Attachment 1: KEY ISSUES

Traffic and Parking Management Plan

Residential amenity

PROPOSED ILLUSTRATIVE PLAN

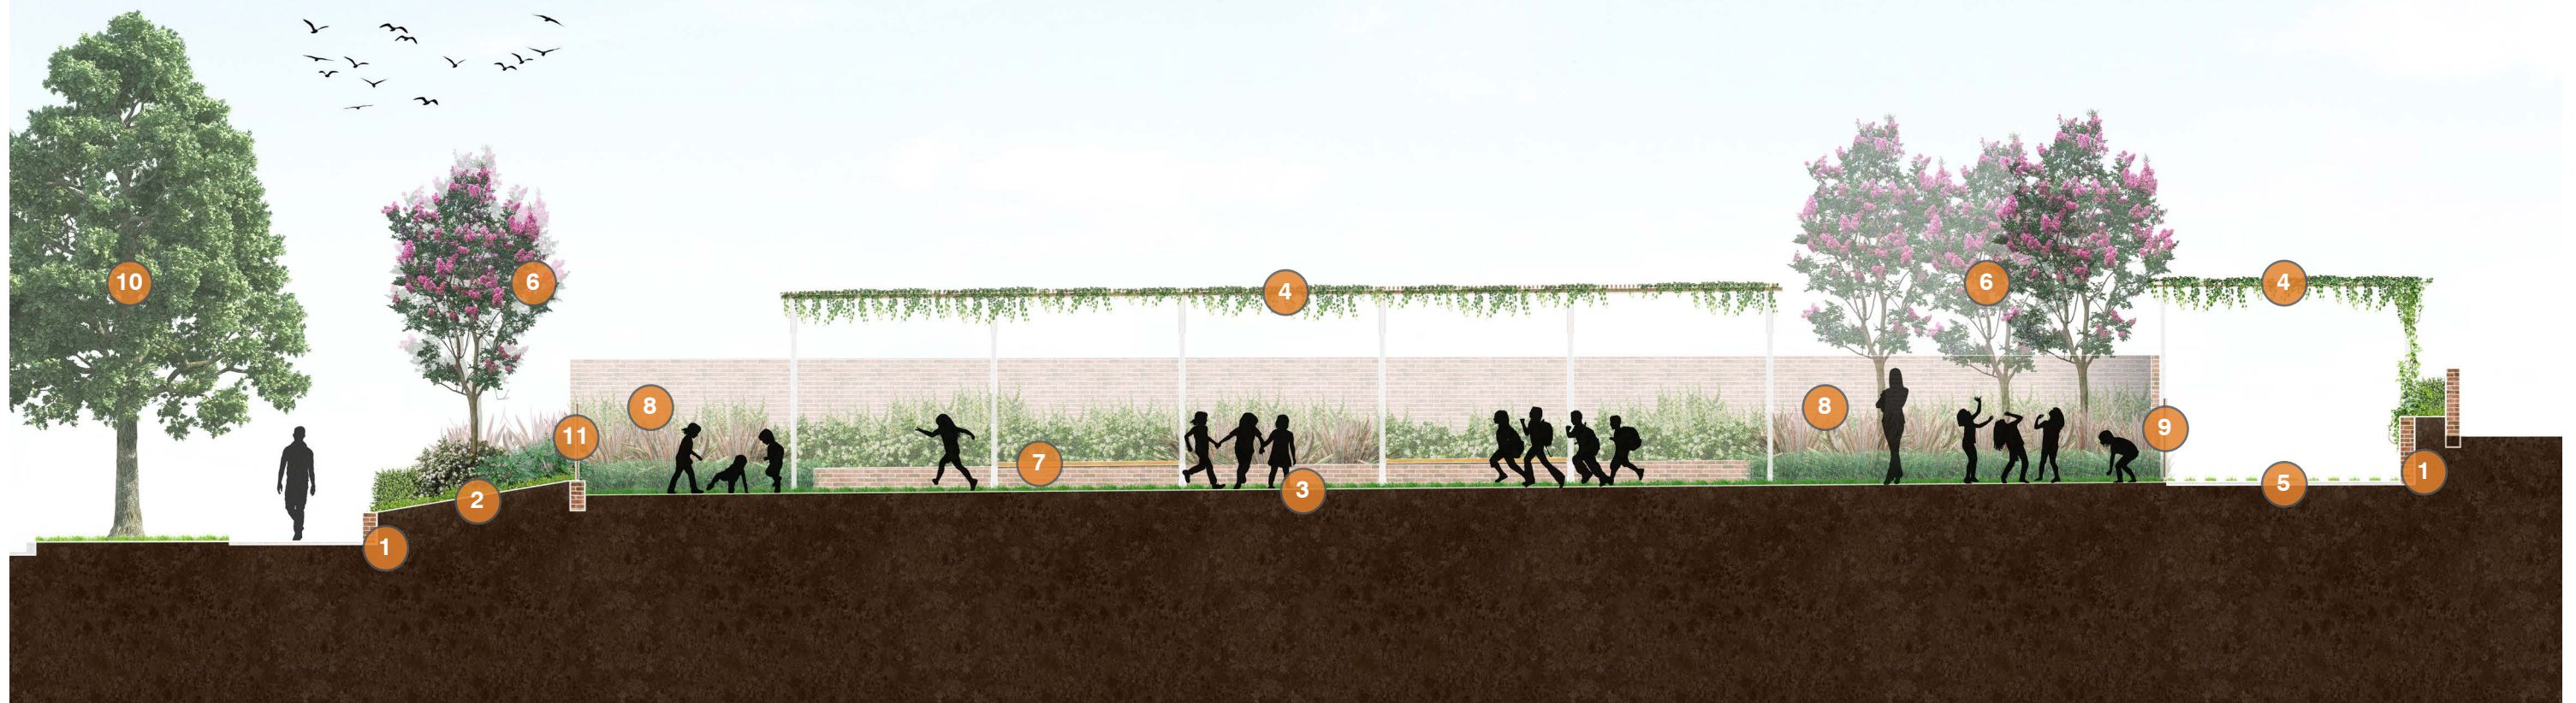
Further information is required regarding the design of the acoustic wall proposed to be installed along the sensitive areas at the junior school campus as identified in Appendix W of the EIS. Details of the specific location, dimensions and materials of the acoustic wall are required.

Amended landscape plans and architectural plans must be provided that include the details of the proposed acoustic wall.
